Planning Application No: 3/2012/0474

Proposed erection of a gate across driveway (listed building consent)

Vicarage Farm, Old Back Lane, Wiswell, Lancashire, BB7 9BS

DIAGRAM OF PROPOSED GATE DESIGN  
HOCKEY-STYLE AND MIRRORS EXISTING  
GATE TO VICARAGE BARN COTTAGE

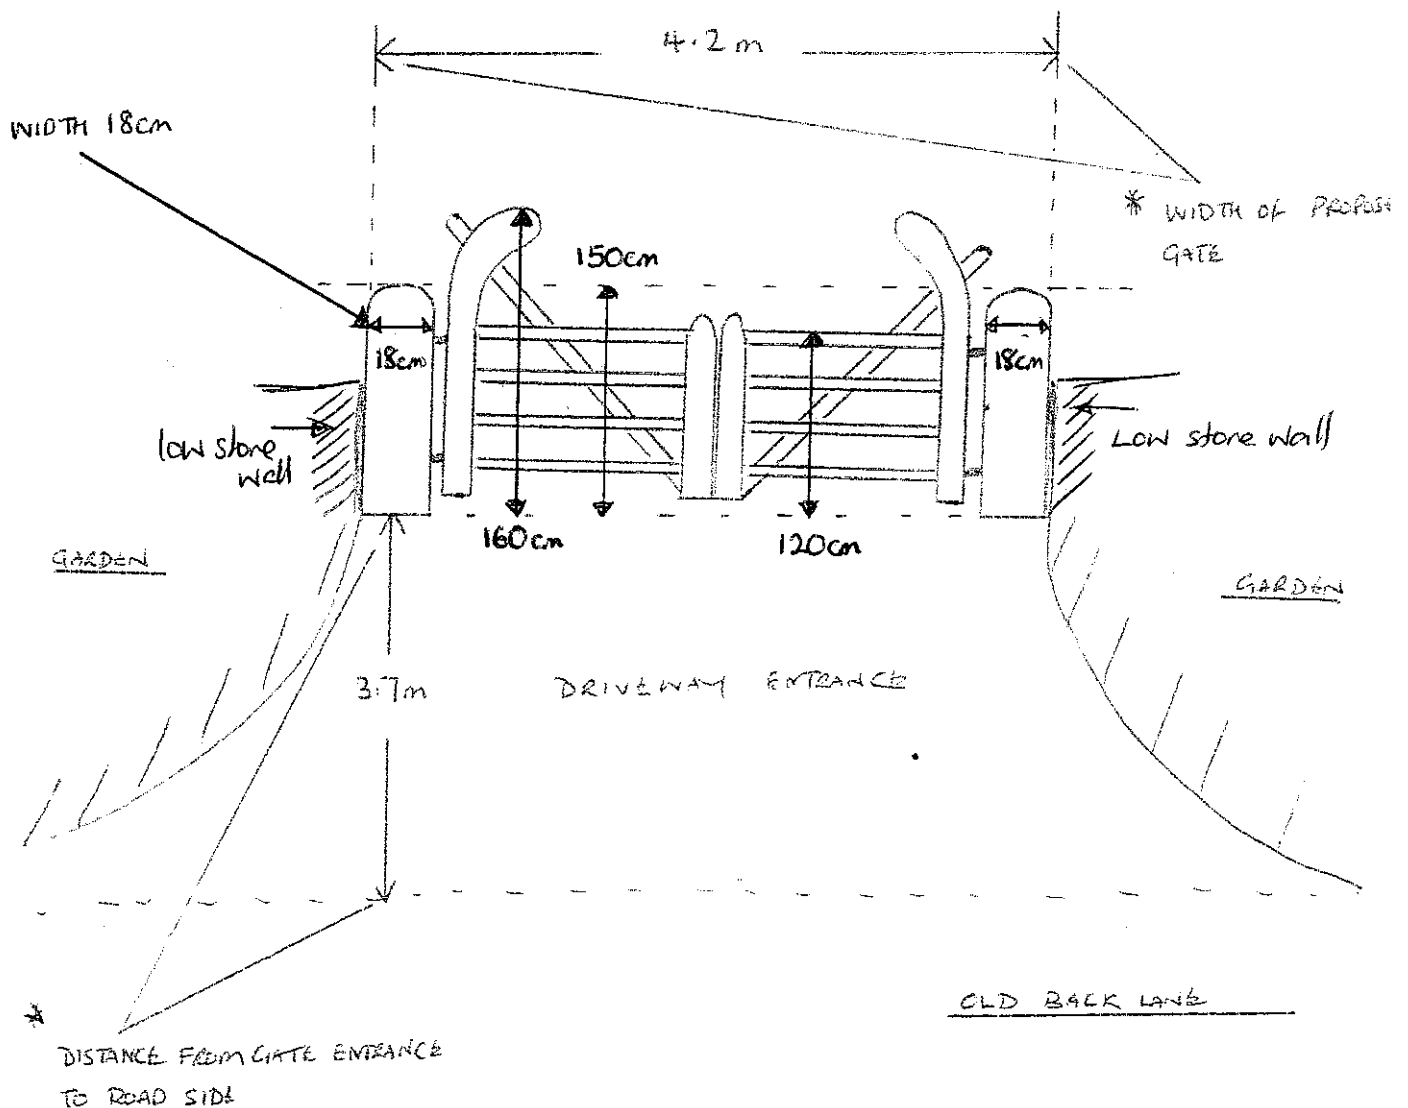
The above application has now been considered by the Parish Council and Members have no objections in principle to the erection of a gate. However, the visibility sightline of the driveway does not comply with the original planning conditions and this must be corrected before a gate is erected. The Councillors have requested that the Environment Directorate be consulted on this matter.
